Subject: Prior Notification Of Works To Tree(s) In A Conservation Area - AB/145/21/TC

Application ref: **AB/145/21/TC**

Location: 54 Maltravers Street, Arundel, BN18 9BQ

Works proposed: 1no. yew tree - Reduce crown size to approx. 12m in height and approx. 7m in spread. Shape the remaining canopy and remove dead and crossing branches within the Arundel Conservation area

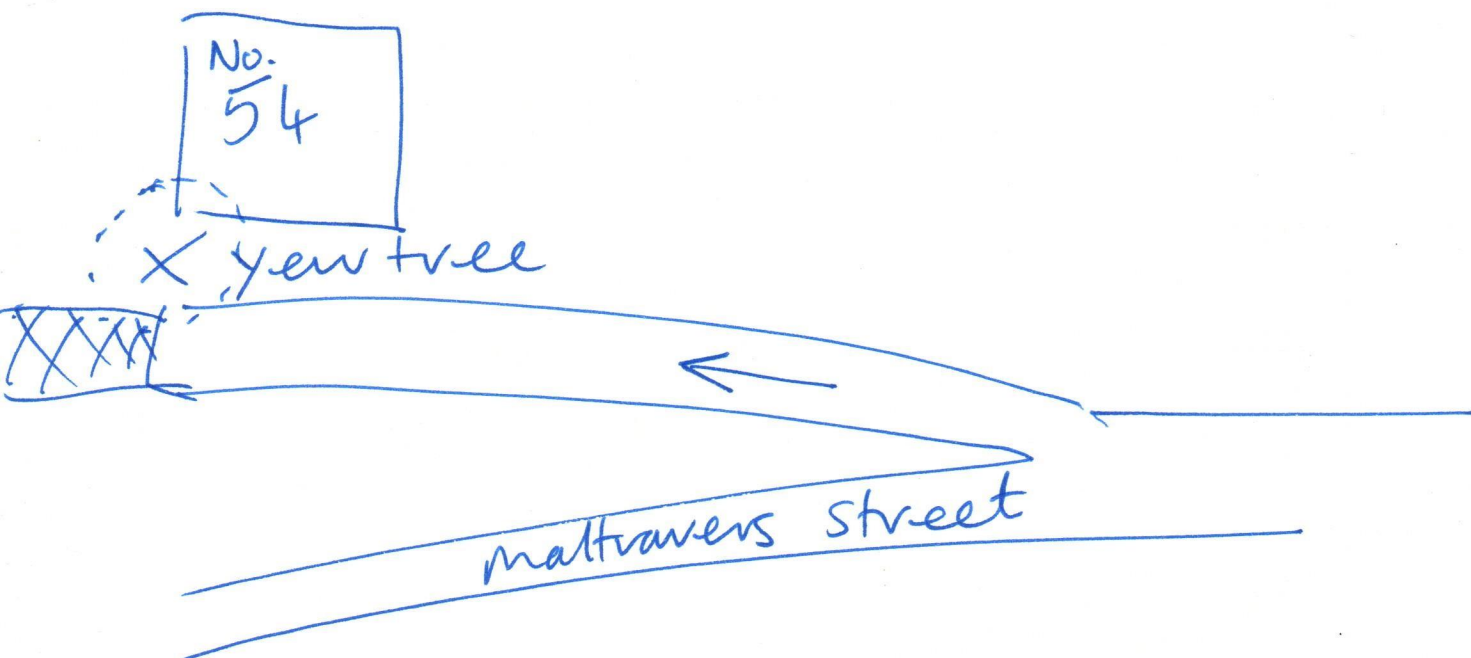
There will be a minimal reduction in overall crown volume, as the tree is approximately 13m tall, with a stem diameter of approximately 10m. The majority of lateral spread reduction will occur on the aspect (roadside), leaving a more balanced looking structure on completion.

It would be beneficial to the tree's response/recovery from pruning; to sever ivy low on the main stem to prevent ivy establishing throughout the crown and facilitate activation of dormant buds.
